## Application for a Non-Material Amendment Following a Grant of Planning Permission

Conversion of attached garage to living accommodation, kitchen, rear two storey extension, first floor extension above former garage with front facing balcony , Porch extension to front of property, changes to fenestration..

22/01119

Change the byfold doors to the front left elevation, former garage, to four number fixed slot windows approximately 600 mm wide x 1500 mm high

23 Bayham Road  
TN2 5HR  
(Proposed windows)  
ODA 1228 03A

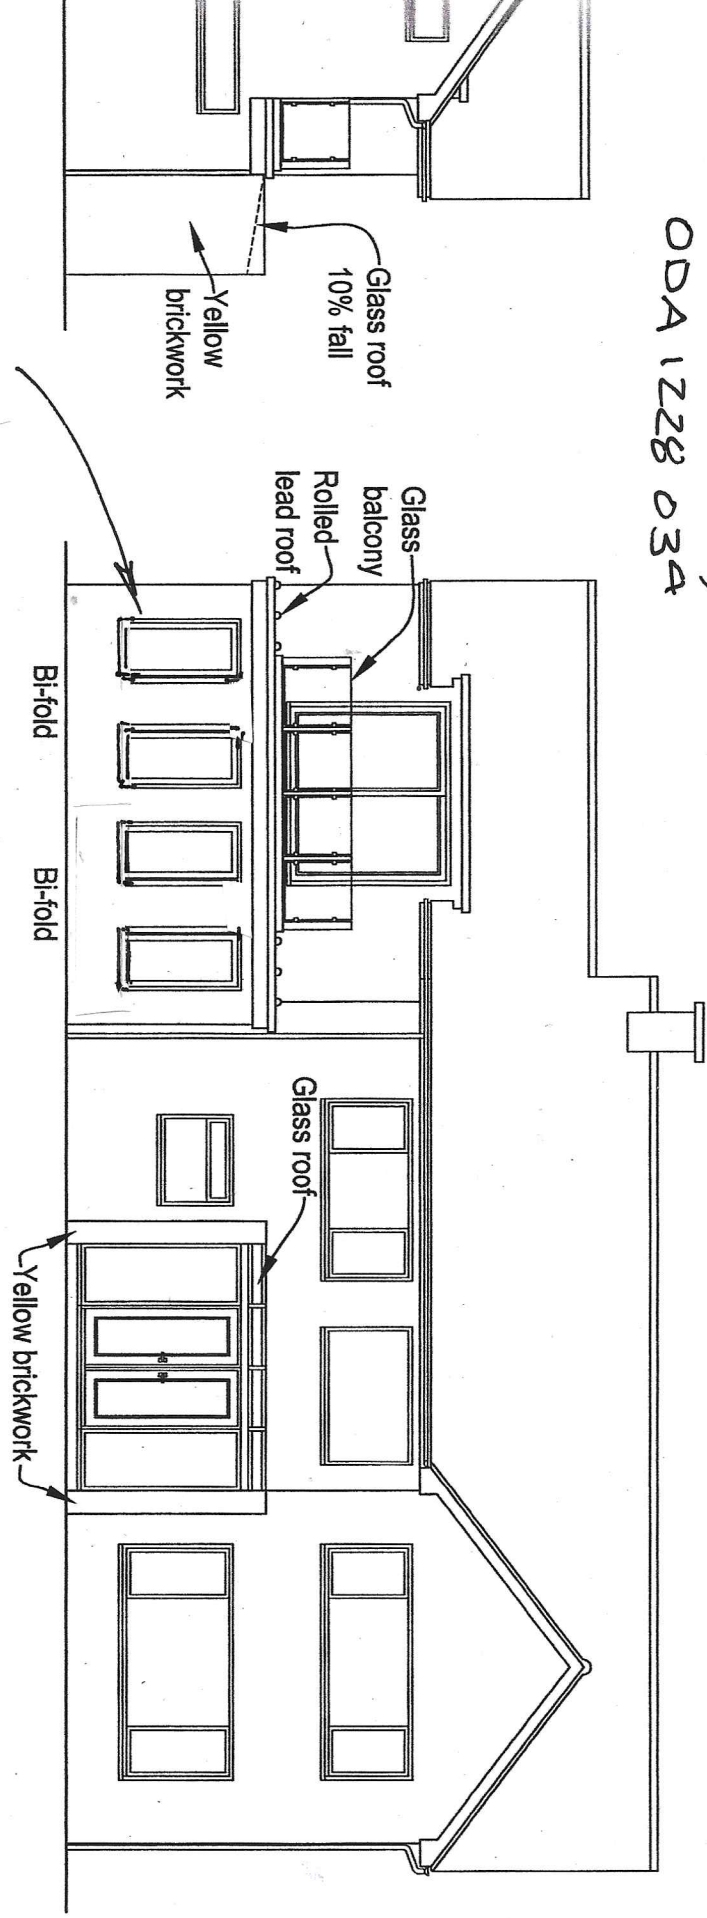
To help maintain the integrity of the internal facility to help screen the room from users of the footpath and standing vehicles at the junction with the main highway

ODA 1228 03A Showing 4 windows replacing byfold doors
